Persimmon Homes Thames Valley

North Littlehampton, Phase 2 comprising Parcel C1 and Part Parcel B2, B4 and C2

Stage 1 RSA – Road Safety Audit Response Report

Stage 1 RSA - Road Safety Audit Response Report

GENERAL ARRANGMENT DRAWING (1 OF 2)

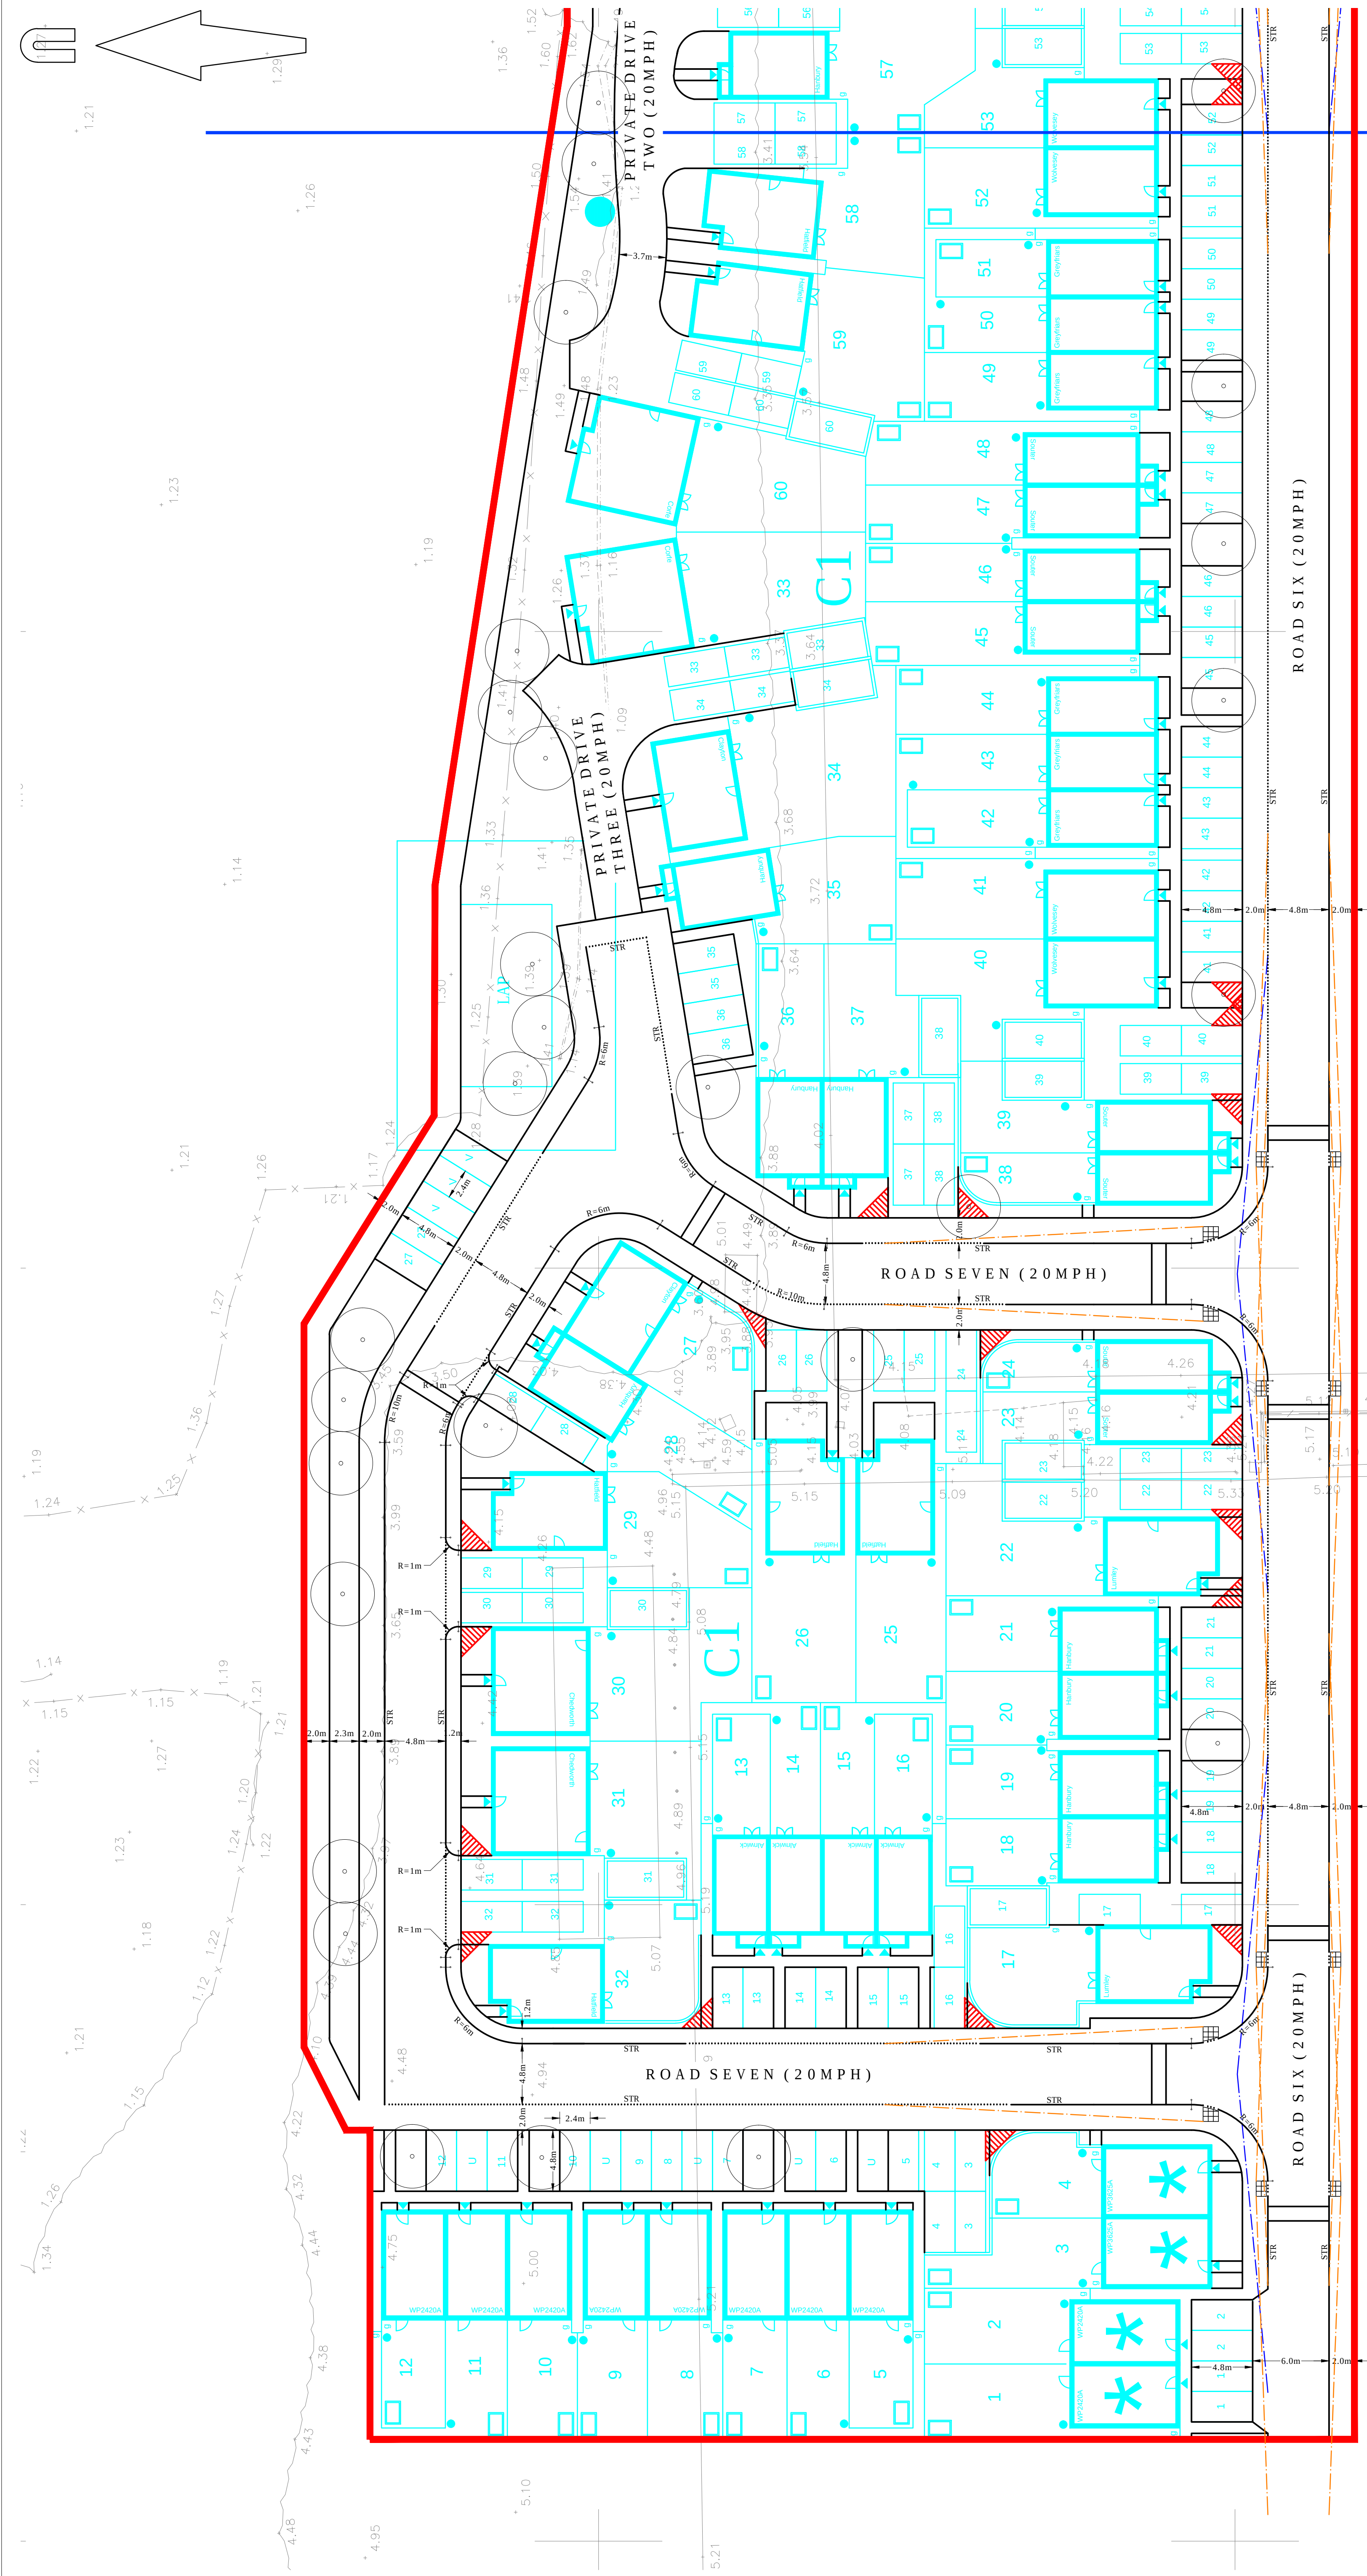
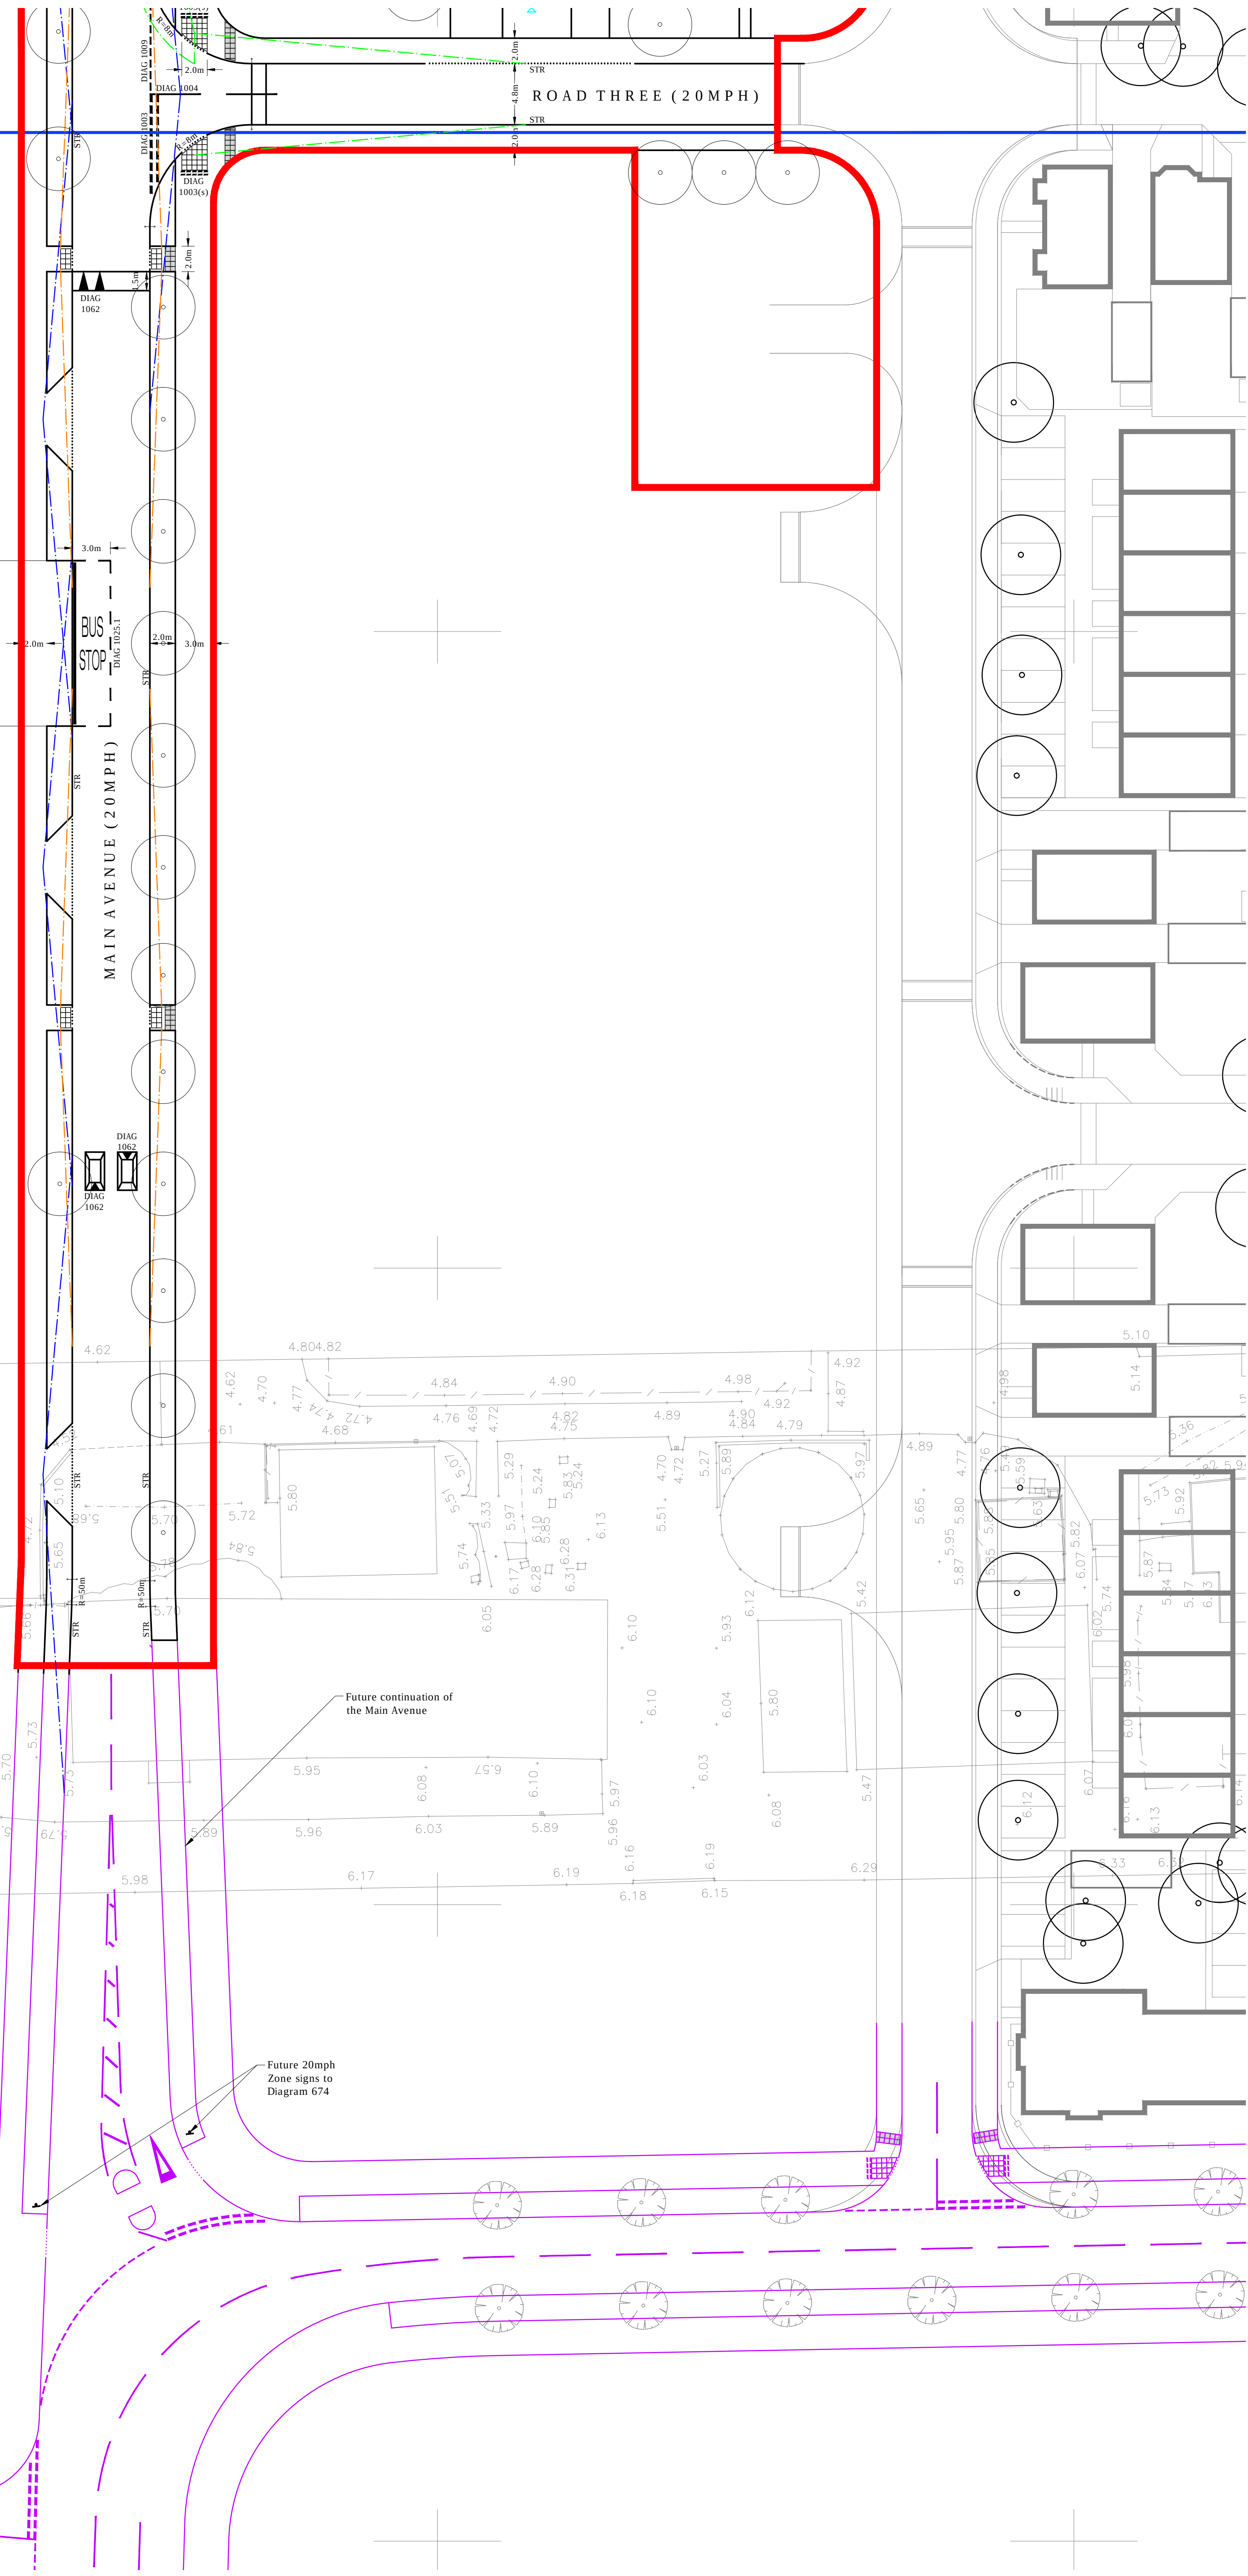
Item	Problem	Recommendation	Designer's Response
2.1	Location: General Summary: Visibility splays Junction visibility splays have not been detailed consistently on the drawings submitted at this stage. A number of splays are shown to the channel line and others are shown to the centre line / offside lane. Forward visibility splays have not been detailed. Pedestrian inter-visibility splays have not been detailed on all of the general arrangement drawings provided. It will be important that adequate splays are provided, this should include junction, pedestrian inter-visibility and forward visibility splays.	Provide visibility splays in accordance with relevant design standards and ensure that the splays will be kept free from obstruction. Any vegetation within the splays should be maintained to ensure that it does not extend beyond a vertical height of 0.6m. If planters are to be provided then these, together with any foliage which they contain, should also not extend beyond a vertical height of 0.6m.	The Design speed of the development is intended to be 20mph. As a result, in accordance with LTN 1/07 Traffic Calming measures are proposed with a maximum of 70m spacing. In consideration of the above, visibility splays provided are indicated as 2.4m x 25m, as set out in MfS. MfS suggests two methods of indicating visibility 'y' distances along the near side kerb line (thus providing maximum visibility). However, some circumstances make it unlikely that vehicles approaching from the left on the main arm will cross the centreline of the main arm. Although the design does not physically restricted vehicles from approaching on the wrong side of the carriageway, there is one instance, the junction of Road Four with the Main Avenue, where visibility to the left is restricted by parking spaces. In this instance, the design incorporates a visibility of 2.4m x 25m where the 'y' distance is achieved not to the nearside channel but to a point approx. 1.5m off the nearside channel. The Designer considers that provision of a visibility splay that achieves the required 'x' distance of 25m to a point 1.5m off of the nearside channel, will still enable emerging vehicles to see traffic from the left that may be on the opposite side of the carriageway.

Item	Problem	Recommendation	Designer's Response
2.2	Location: Main Avenue (Please refer to reference point 2.2 in Appendix B) Summary: Possible injury to bus passengers as a result of vertical deflection. A raised table at this location is likely to be detrimental to bus passenger safety as vertical deflections will occur as passengers rise from seats and / or use the stairs within the bus, on approach to the bus stop.	Either: 1. Relocate bus stop away from raised table 2. Relocate raised table away from bus stop	Accepted. The raised tables have been designed with 1 in 20 approach ramps and adequate hump length (greater than 6m) as recommended by LTN 1/07. However, it is acknowledged that when humps are used on bus routes it may not be appropriate to locate them close to bus stops. As a result and as recommended, the bus stop has been relocated eastwards between two traffic calming features. Furthermore, the calming feature on the approach to the bus stop has been changed from a raised table to a speed cushion which is more easily traversed by an approaching bus.

2.3	Location: Uncontrolled crossing point east of bus stop (Please refer to reference point 2.3 in Appendix B) Summary: Crossing pedestrians masked by stationary bus If a bus is stationary within the bus stop then the crossing point sited to the east of it will be masked from drivers approaching from the west. This could result in pedestrians stepping out front of a moving vehicle, potentially resulting in injury. The Audit Team have considered the same issue with the crossing located to the west of the bus stop. However, it was agreed that this did not provide a safety risk as westbound drivers will already be slowing significantly for the raised table prior to the crossing point.	Relocate eastern crossing point away from the bus stop, ensure appropriate forward visibility splays to the pedestrian landing points can be achieved.	Accepted. Bus stop relocated. Visibility splays to pedestrian crossing locations indicated as recommended.

Item	Problem	Recommendation	Designer's Response
2.4	Location: General Summary: Junction markings within the internal residential development The priorities indicated are unnatural and would probably quickly be disregarded by residents and frequent users. The change in surface and raised junction tables would add an element of uncertainty that might reduce speeds and increase concentration to those unfamiliar with the development.	Omit junction markings on raised tables / block paving within the internal road network of the development site.	Accepted. It is considered that the giveaway markings on the Main Avenue junctions should be retained as these provide priority to the Main Avenue traffic route. However, giveaway markings on other junctions within the internal road network have been omitted as recommended.

2.5	Location: General Summary: Ramp warning triangles There are a number of ramps / raised tables provided within the internal residential layout. It will be important that approaching drivers / riders are able to identify these ramps on approach so that they can adjust the speed / riding position as appropriate to reduce the risk of losing control.	Provide white warning triangles (Diag 1062) on all speed reducing ramps.	Partially Accepted. It is intended that the area will be subject to a 20mph Zone and thus utilise signs to Diag 674 on entry to the Main Avenue. TSM Chapter 5 indicates that in 20mph zones signed with diagram 674, road markings are not required on road humps, speed cushions or thumps; however they may be used if the traffic authority considers them appropriate. It is understood that such markings have been omitted within the agreed B3/B5 development proposals. In consideration of the above, triangular road markings to Diag 1062 shall be used for humps and cushions on the Main Avenue but omitted within the internal road network.
